WELWYN HATFIELD COUNCIL – DEVELOPMENT CONTROL
DELEGATED REPORT

APPLICATION No:	S6/2007/1724/MA
------------------------	------------------------

Mymwood House was built as a residential dwelling around 1820 and is a two-storey, detached, white rendered building with a pitched slate roof. Mymwood House has a single storey, flat roofed extension to the rear. The building has been used as a residential care home for the elderly since the mid-1980's and before this had been used as a boarding school from the 1930's. Mymwood house is set back from the highway by approximately 65m. To the front of the site is a detached building Mymwood Lodge. Both Mymwood House and Mymwood Lodge are Grade II Listed Buildings. The site lies within the Metropolitan Green Belt and to the east of the settlement of Brookmans Park.

Date: January 2007  
 Drawing: Proposed Elevations  
 Scale: 1:200  
 Ref: Final Design - dwg 2

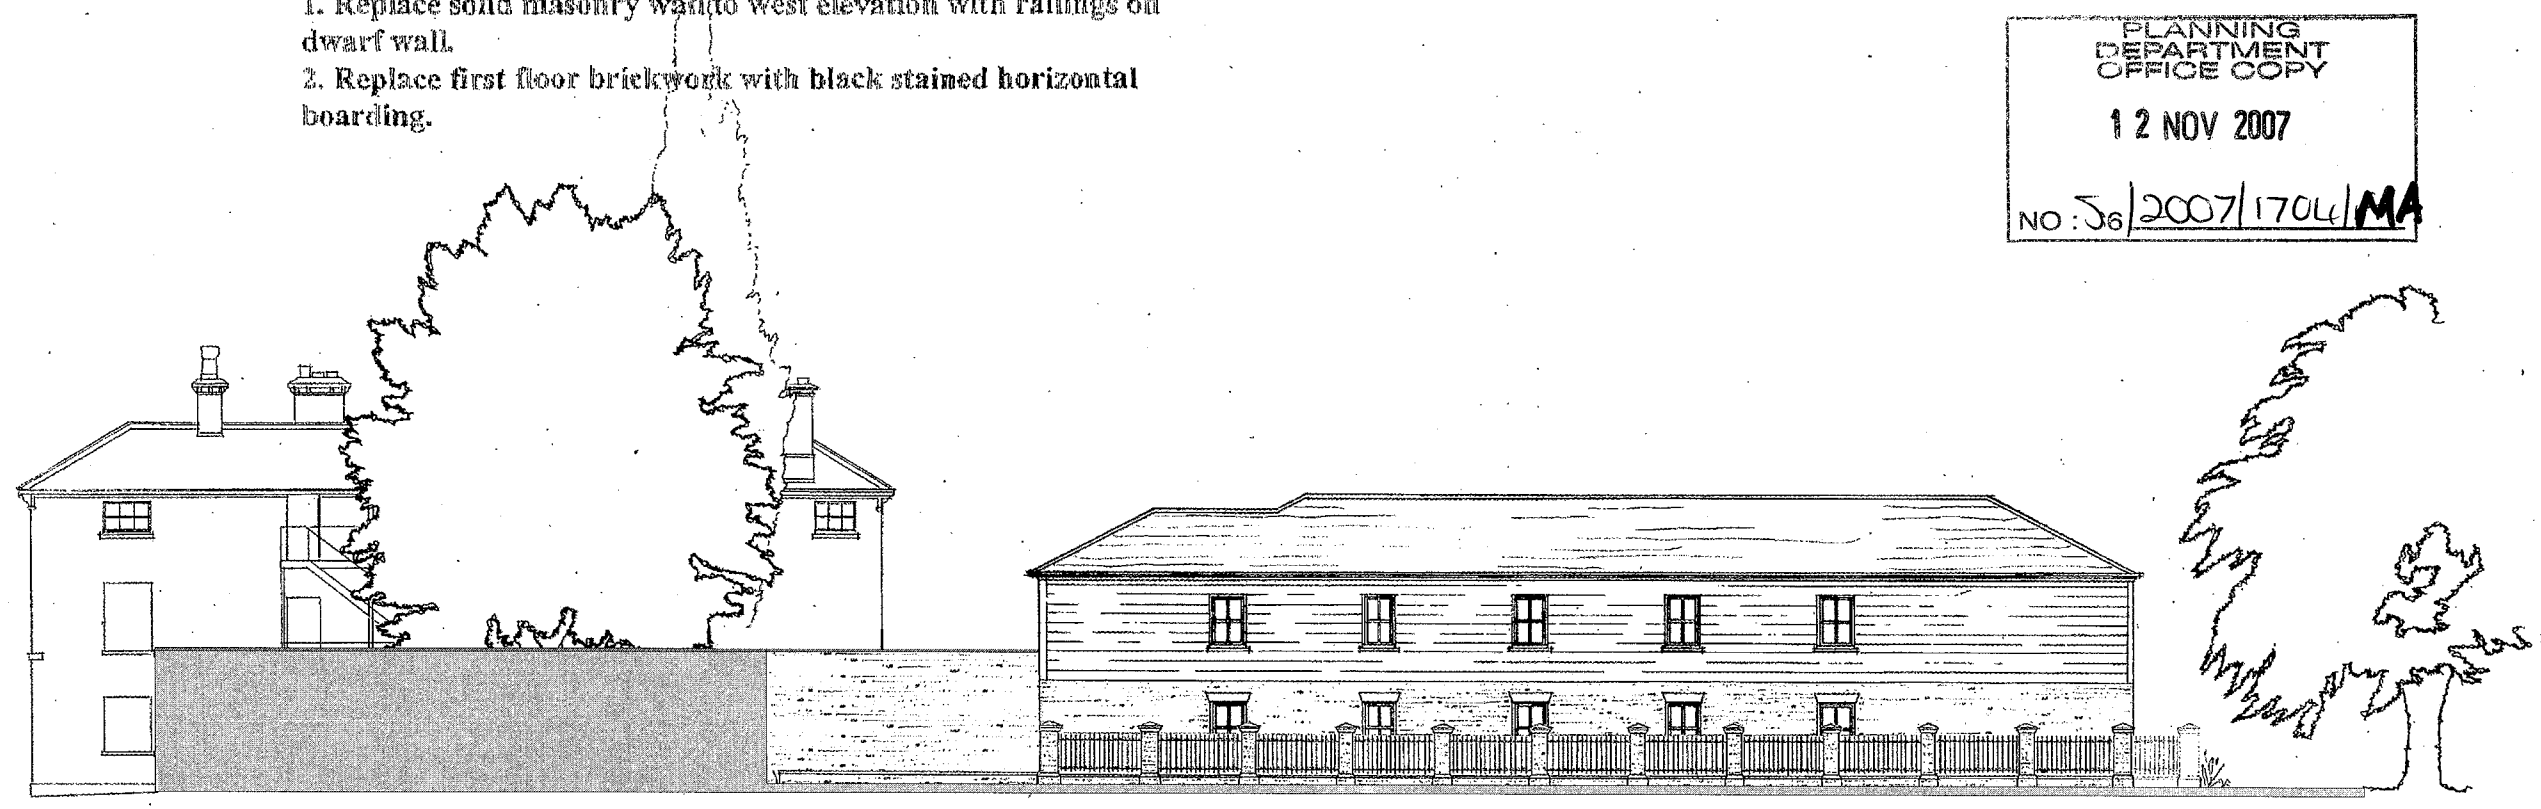
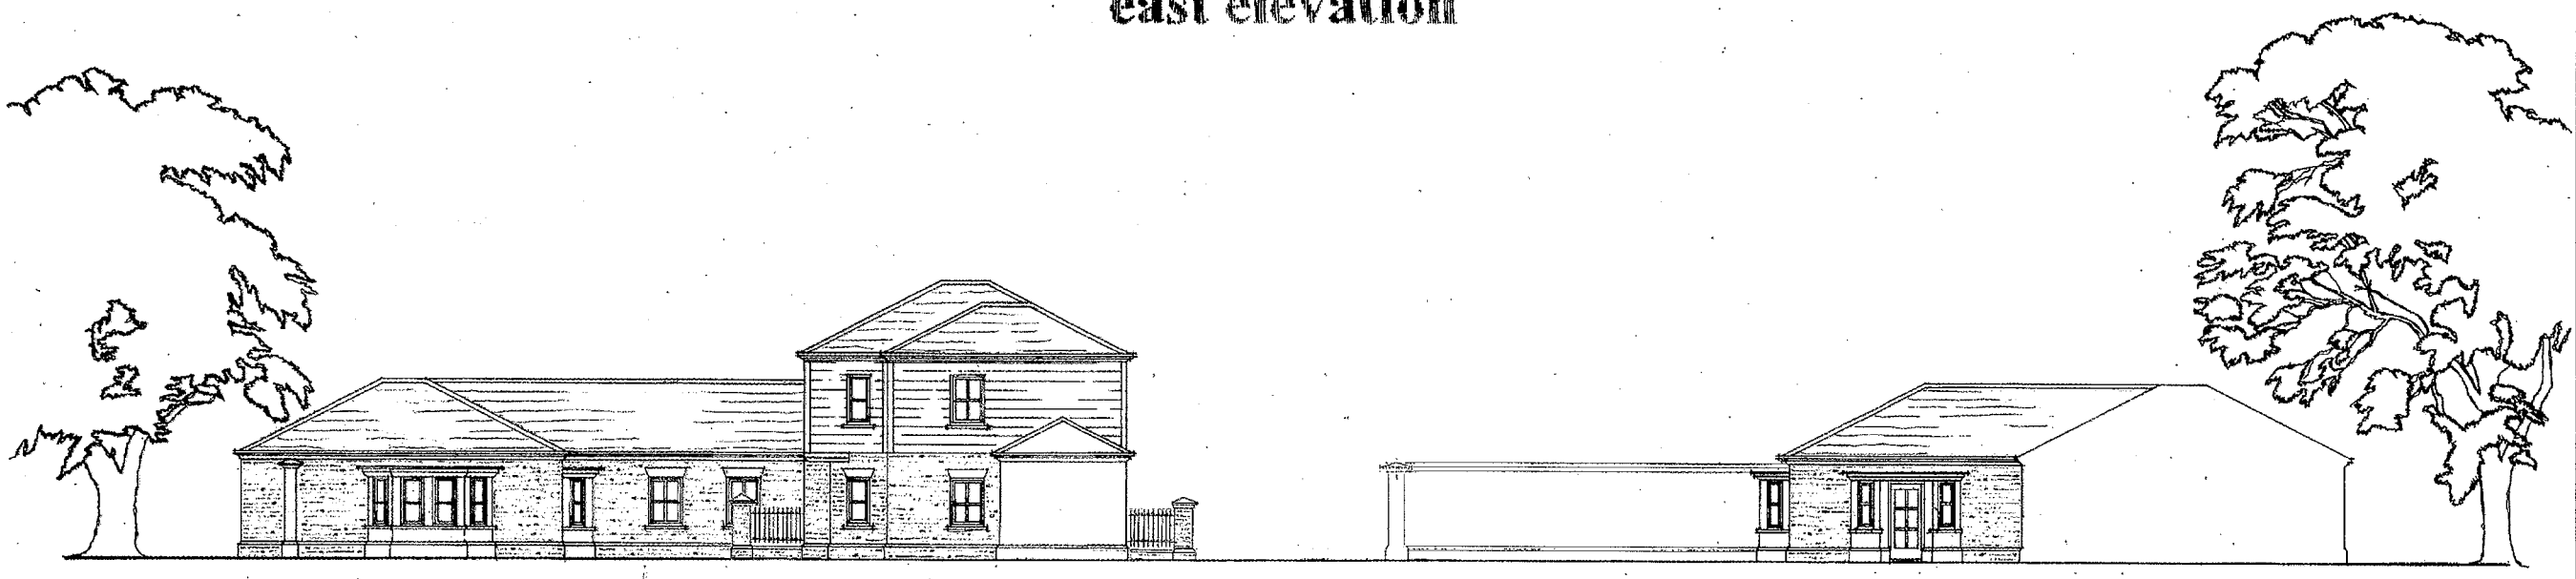
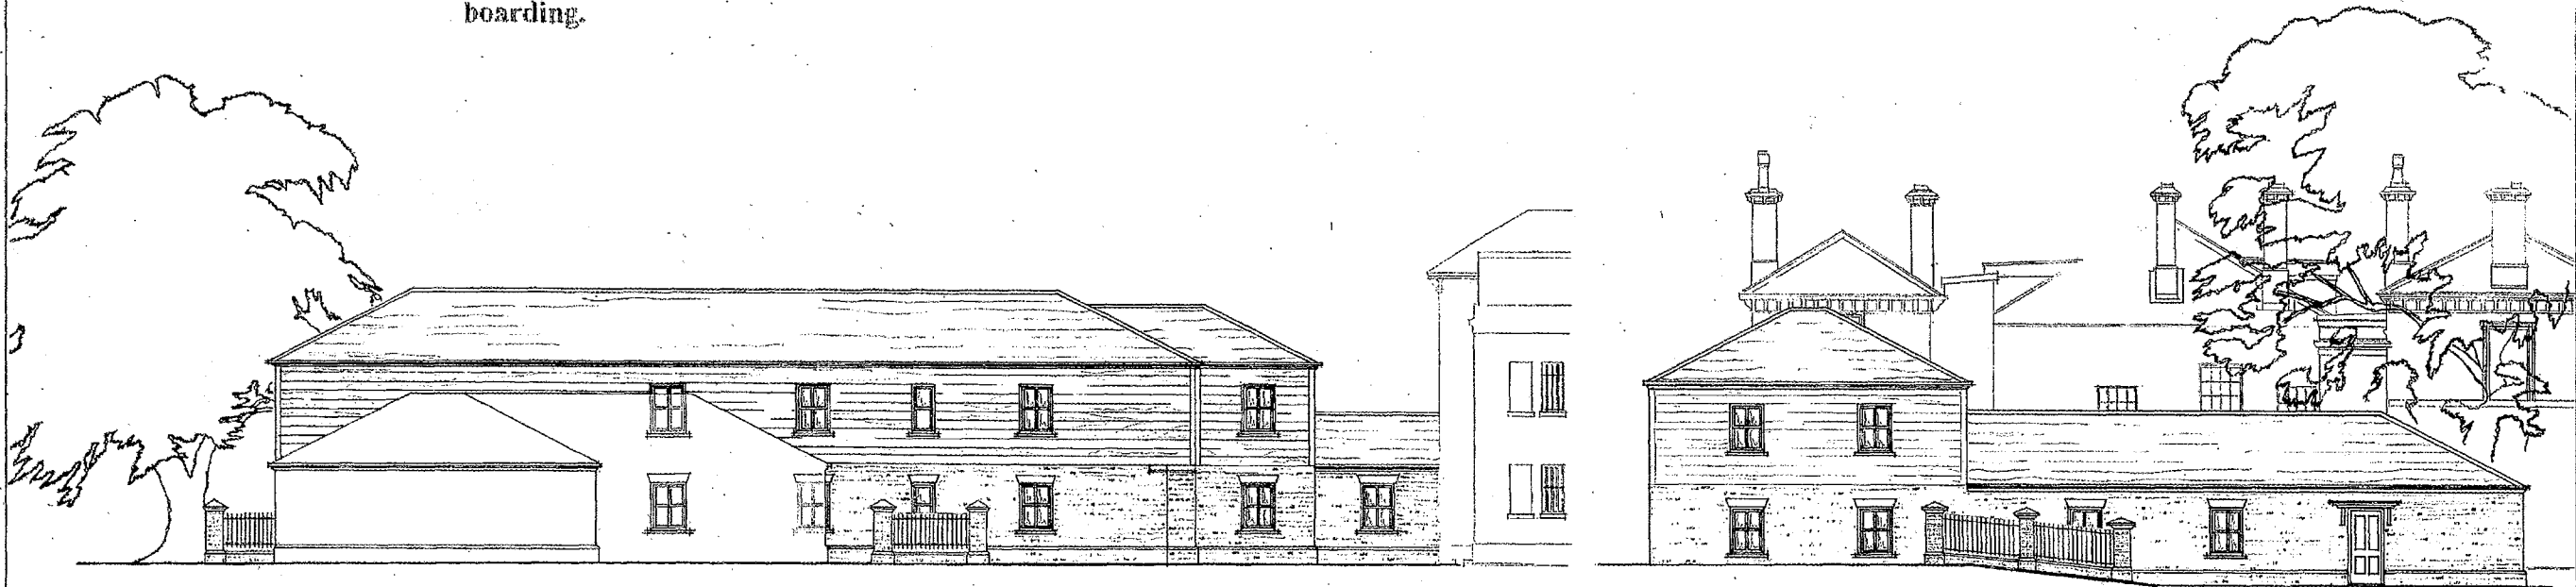
Within the previous application alterations were requested to alter the window heads and arches to be brick rather than haddenstone. The drawings have not yet altered this feature, therefore any consent would need a condition to ensure this is done prior to construction.

1. C.2.1 – Time Limit Full Permission
2. C.5.1 – Material to be submitted
3. Notwithstanding the details on the approved plans, full details of amended elevations showing brick headstones and arches are to be submitted and approved in writing. Notwithstanding the provisions of the provisions of the Town and Country Planning, General Permitted Development) Order 1995 (or any Order revoking and re-enacting that Order with or without modification) no additional windows or similar openings shall be constructed in the flank elevation of the original dwelling and extension

Drawing Title : Proposed
Basement Layout

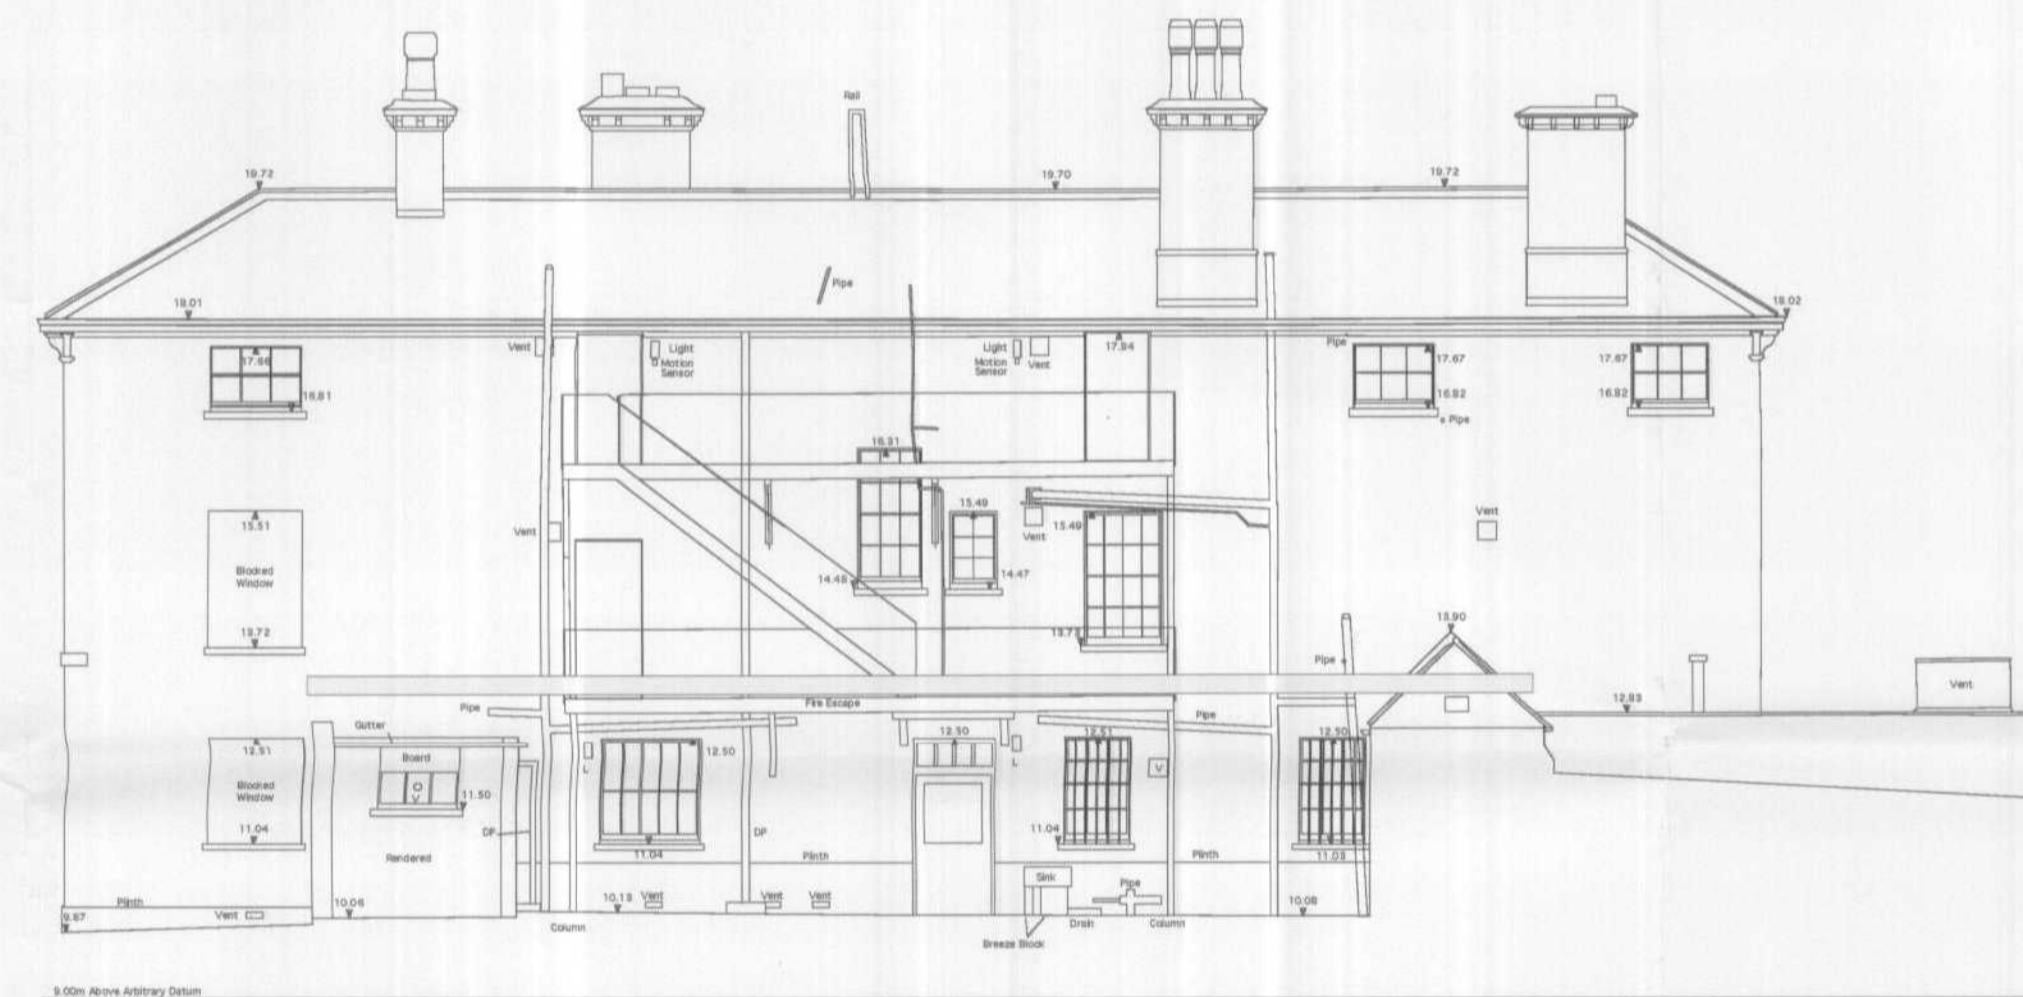
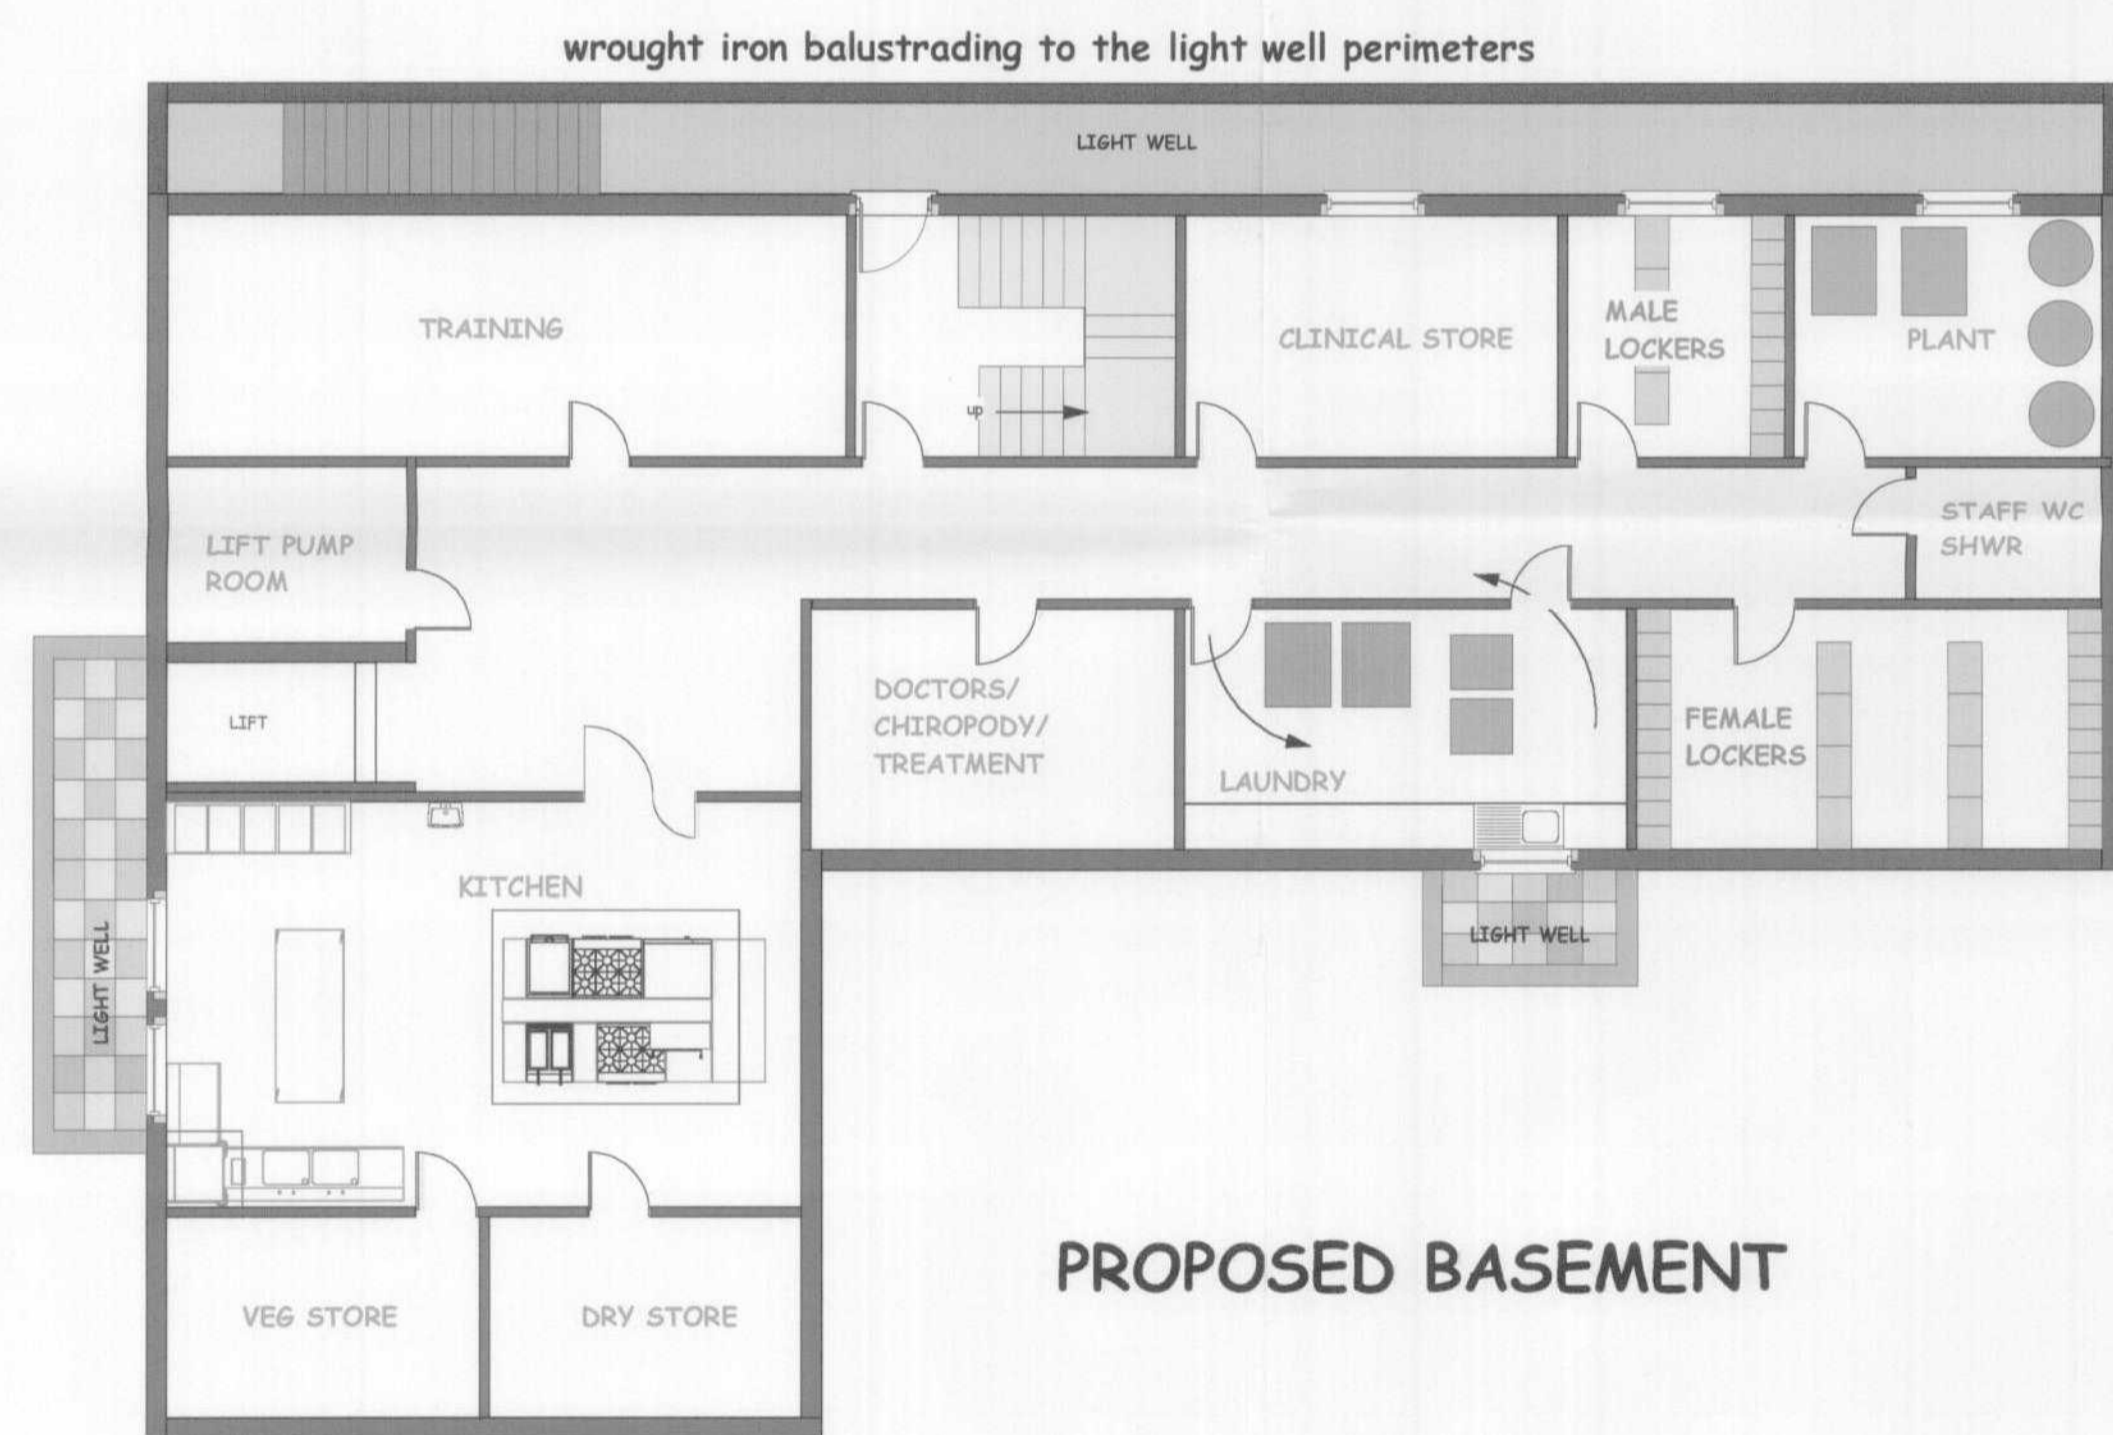
To the rear and west small light wells would be enclosed by brick pillars and railings. These additions would be viewed against the approved extensions and would not appear prominent or out of place.
